From: Thomas Callaway
Sent: 11 December 2014 15:07
To: Neil Crowther
Cc: Sarah Burrows [REDACTED]
Subject: Oldlands Farm
Attachments: C14443-400 - T4 Attenuation pond.pdf

Following discussions with the site manager at Oldlands Farm, and Sarah Burrows of Hydrock, and also the receipt of a revised drawing showing clearance between the proposed pond outfall and the current ditch bed, the surface water condition can technically be discharged.

PLAN ON ATTENUATION POND  
Scale 1: 500

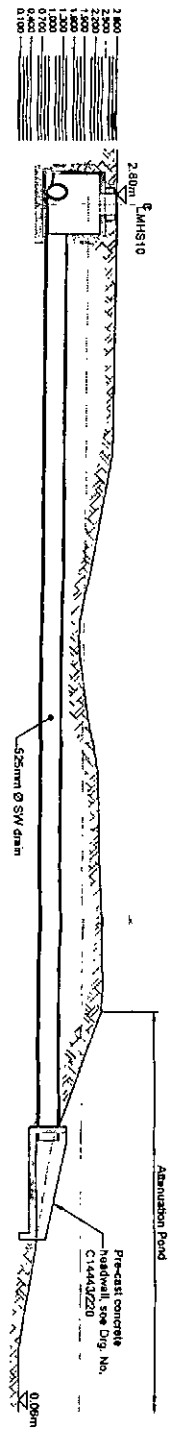
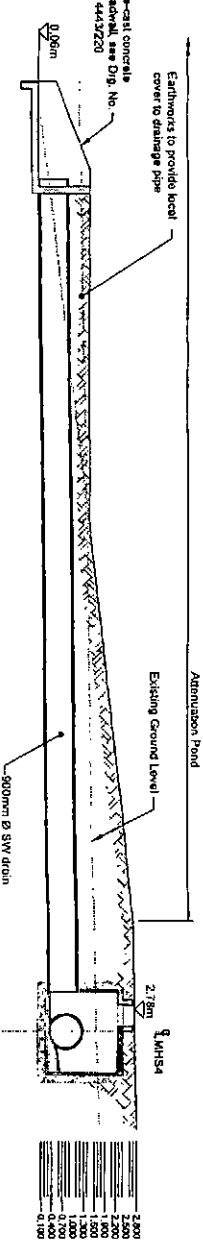
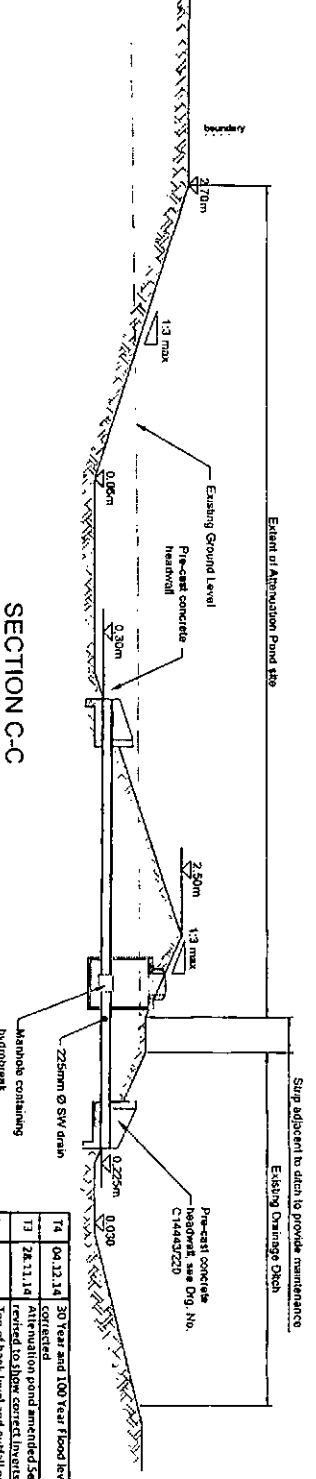
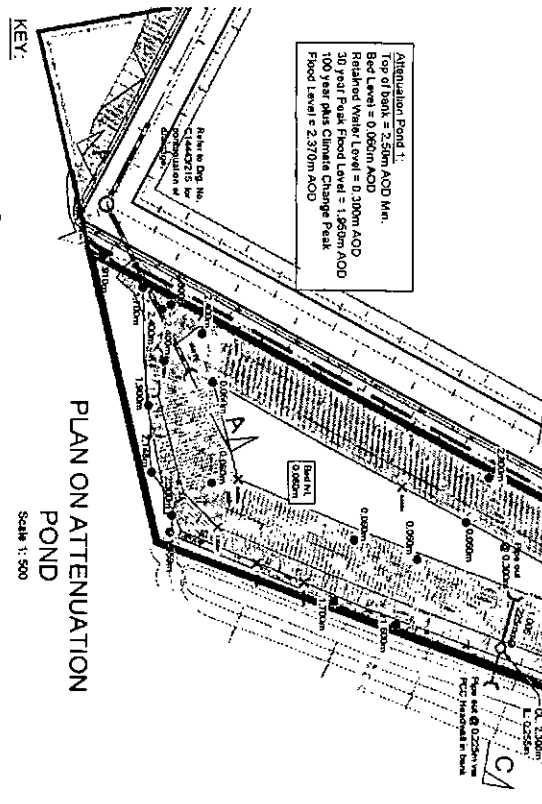
Issues such as maintenance access between the pond and ditch, and additional methods of draining the car park areas are apparently unresolvable, but the system should work. Beyond the scope of this application, the applicant should be considering who will be responsible for maintenance of the ditch, as it is not being taken on by the Rolls Royce site and has been retained by the previous owner. Maintenance work on this ditch is fairly urgent as no IDB work is planned before the IDB is dissolved. It will then fully become the responsibility of the owner.
